Date: 07/16/2025

Re: Framing Items
Location: Lot 345 Serenity (36 Firefly Ln. Fuquay-Varina, NC)
JDS Project No.: RDU2507319
Date of Inspection: 07/16/25

A representative of JDS Consulting arrived on site to observe the issues reported to us by the client, which are presented, along with our recommendations, in this report.

SD2.0

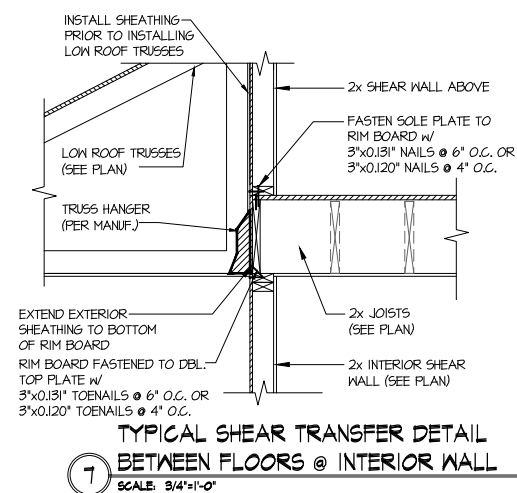
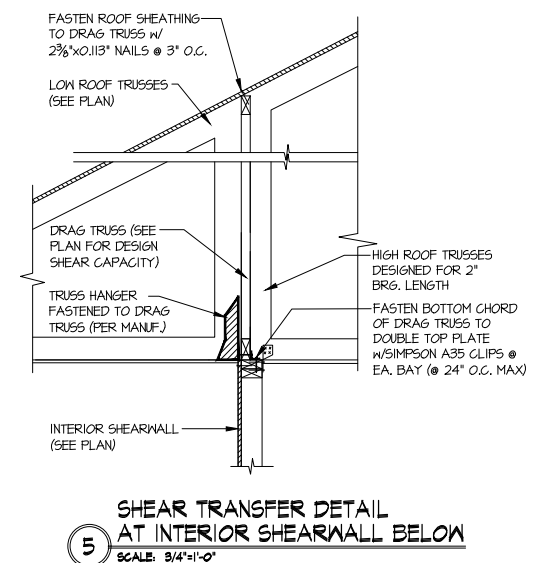
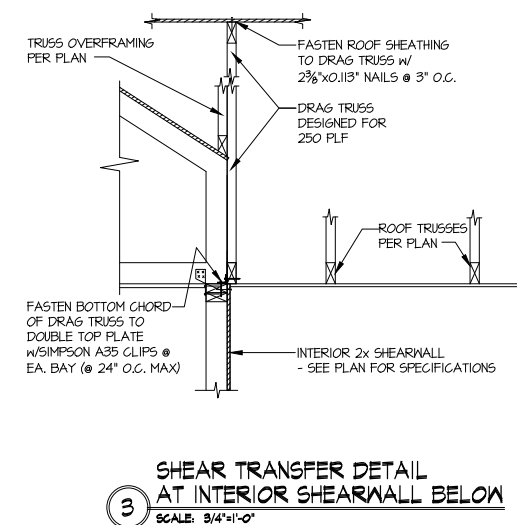
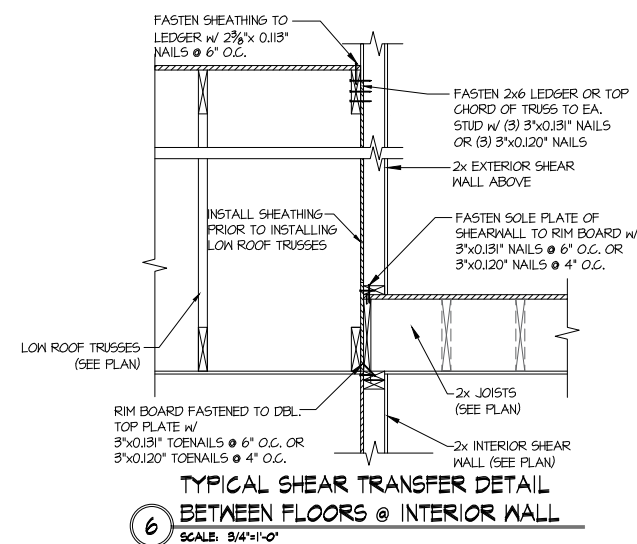
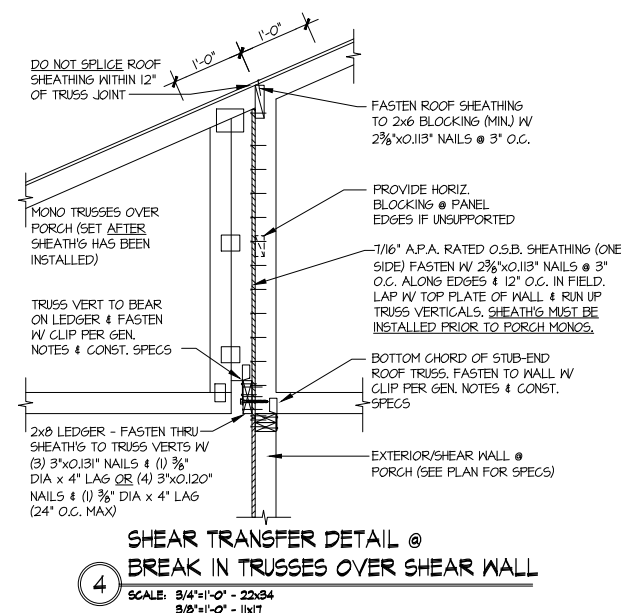
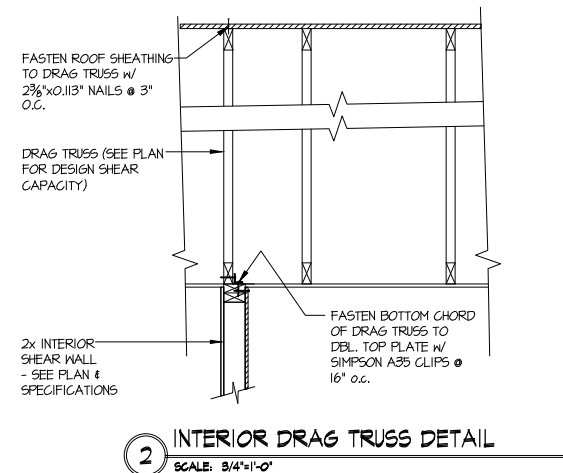
1. The 5th I-joist from the left (from the kitchen) has top flange damage on the left face at the approximate mid-span.
2. The inspector is questioning the continuous 2x6 header that spans over the windows on the 2nd floor on both sides of the house. No wall framing is specified on the plans. The builder stick build the wall framing around the windows. There are (4) king studs between the two windows and (2) kings either side of each window. The 2x6 header is a single ply, and the above gable truss at the right side of the 2nd floor is bearing atop of the top plate. The wall is a 2x4 wall.
3. The client did not install OSB as per detail 7 on page SD2.0 at the front shear wall at the right front of the 2nd floor.

1. Pack out the web by the full depth by 4' long by 3/4" thick OSB centered on the damage attached with construction adhesive and (3) rows of 10D nails spaced at 4" o.c. Then install a 4' 2x4 scab centered on the damage attached with (2) rows of 10D nails spaced at 4" o.c. with (1) row in the web and (1) row in the flange.
2. The continuous 2x6 across the gable at both sides of the house is adequate for the anticipated loading, no further repairs are required.
3. We recommend installing Cross Braced LIB bracing on the backside of the wall for the length of the designed shear wall. Install CS16 strapping along the wall per the detail noted in the following page.
